Recommendation Report for Lawful Development Certificate for a Proposed Use or Development**REF NO:** **AW/140/22/CLP****LOCATION:** 15 Bradlond Close
 Aldwick
 PO21 2RQ**PROPOSAL:** Lawful development certificate for a proposed single storey rear extension.**DESCRIPTION OF APPLICATION**

CDM 2015 Health & Safety Information

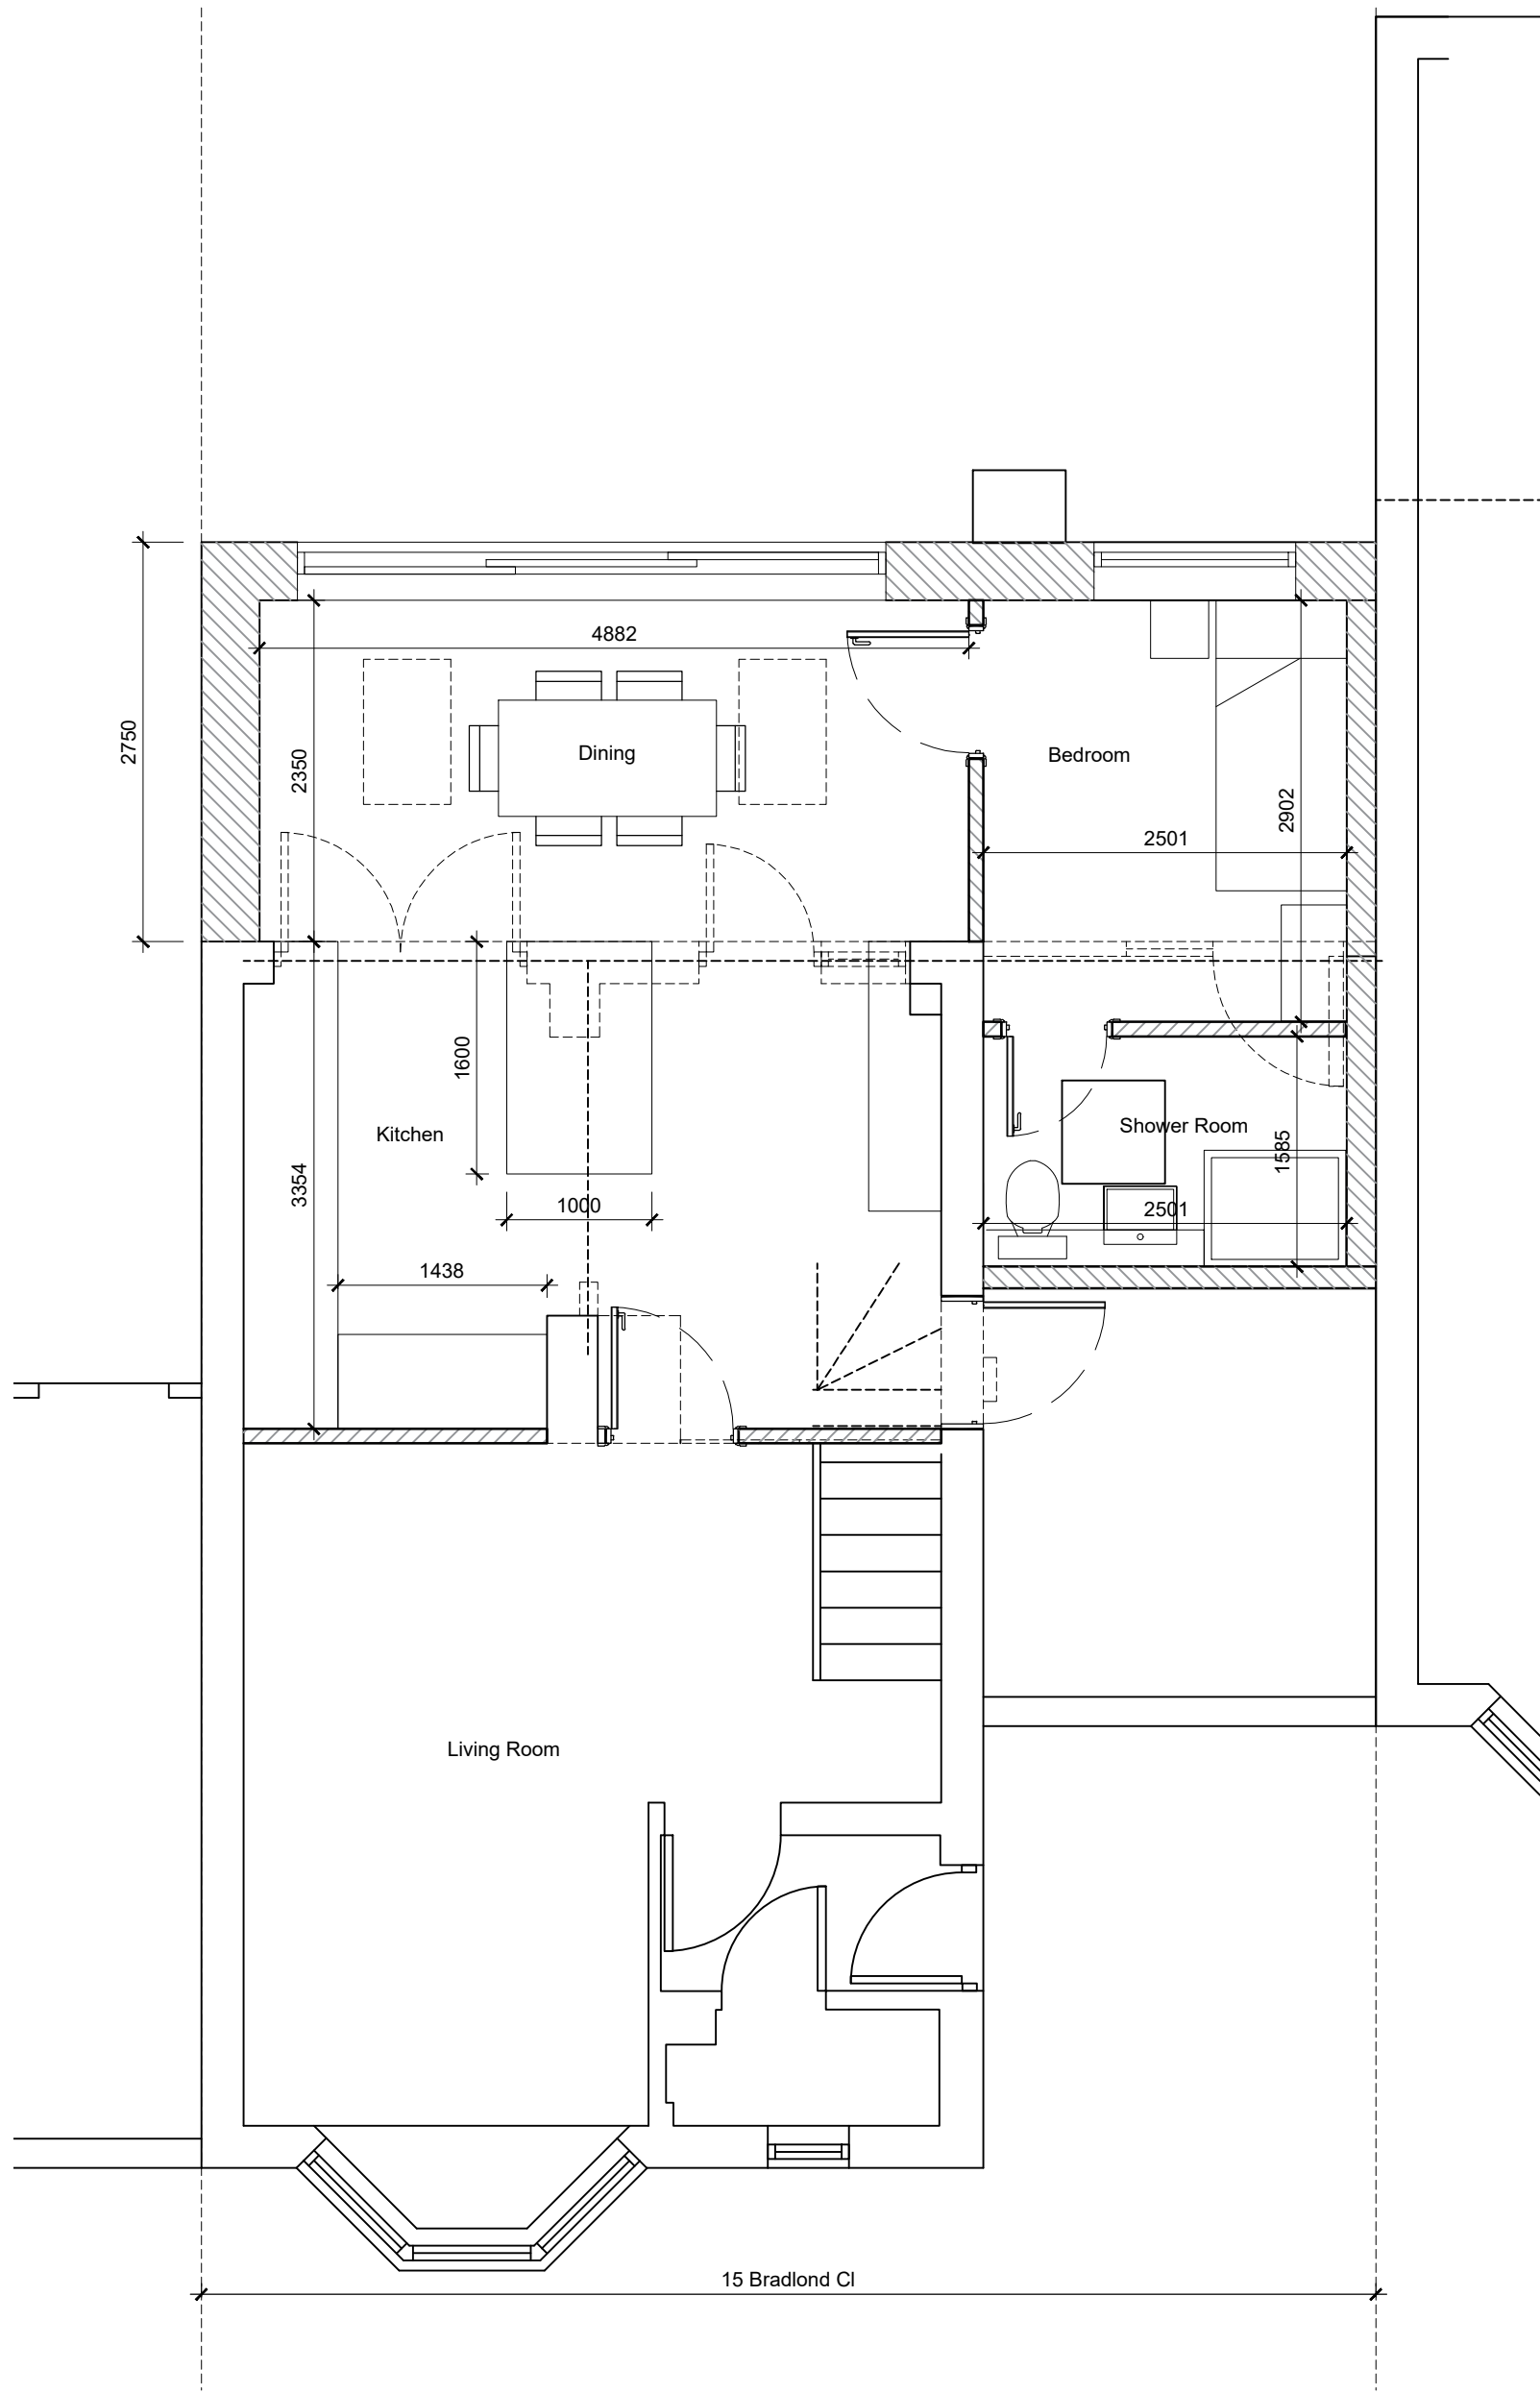
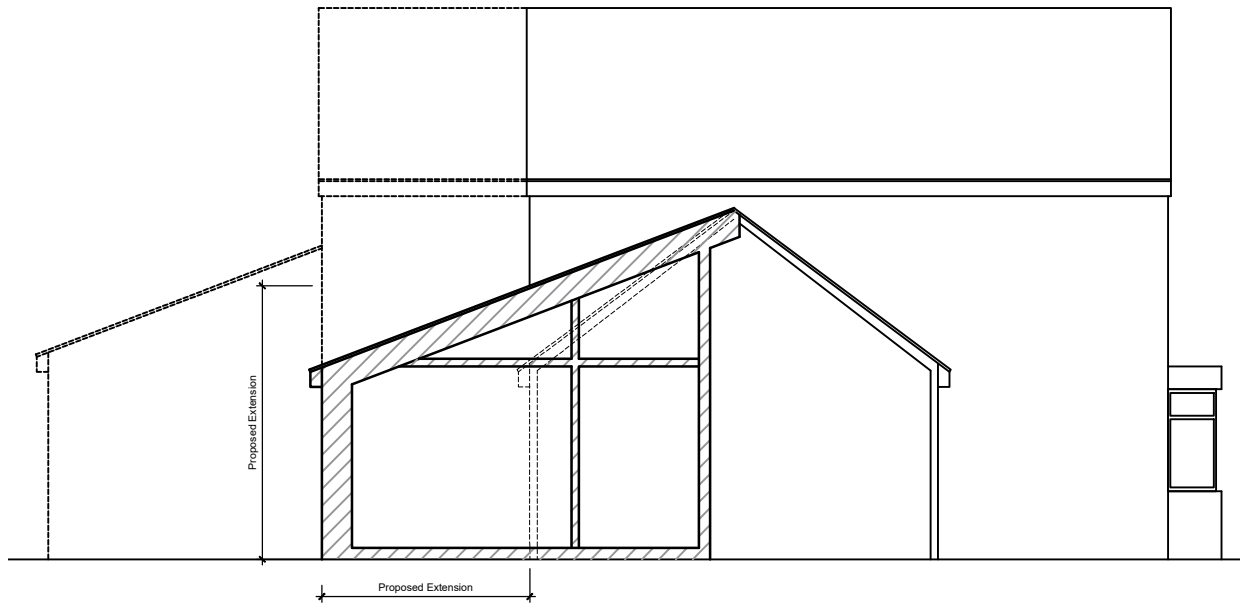
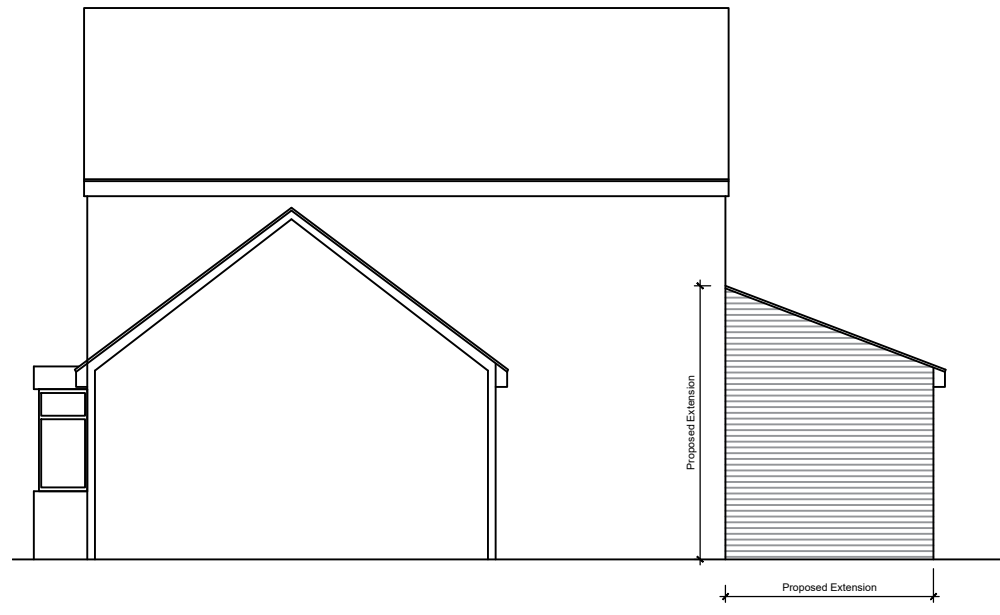
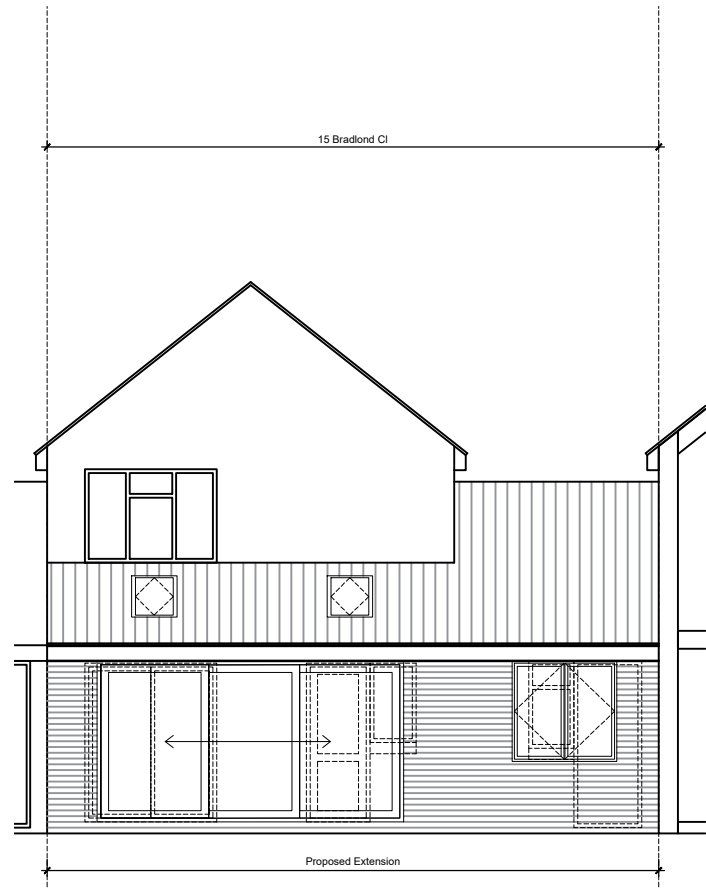
This application seeks a single storey rear extension measuring 2.75m deep and 8m wide, with a pitched lean to roof with eaves 2.6m high and a maximum height of 3.6m. It seeks to regrade one side of the garage roof in order to join with the proposed extension. The regraded roof will join from the extension to the ridgeline of the existing garage roof and retain a maximum height of 4.6m.

The property known as 15 Bradlond Close is a terraced property and is not listed or within a conservation area. The proposed extension and alterations would be of materials to match that of the existing.

The extension complies with relevant sections of Class A and is permitted development. The regrading of the roof complies with relevant sections of Class B and is permitted development. As such the development does not require the submission of an application for full planning permission.
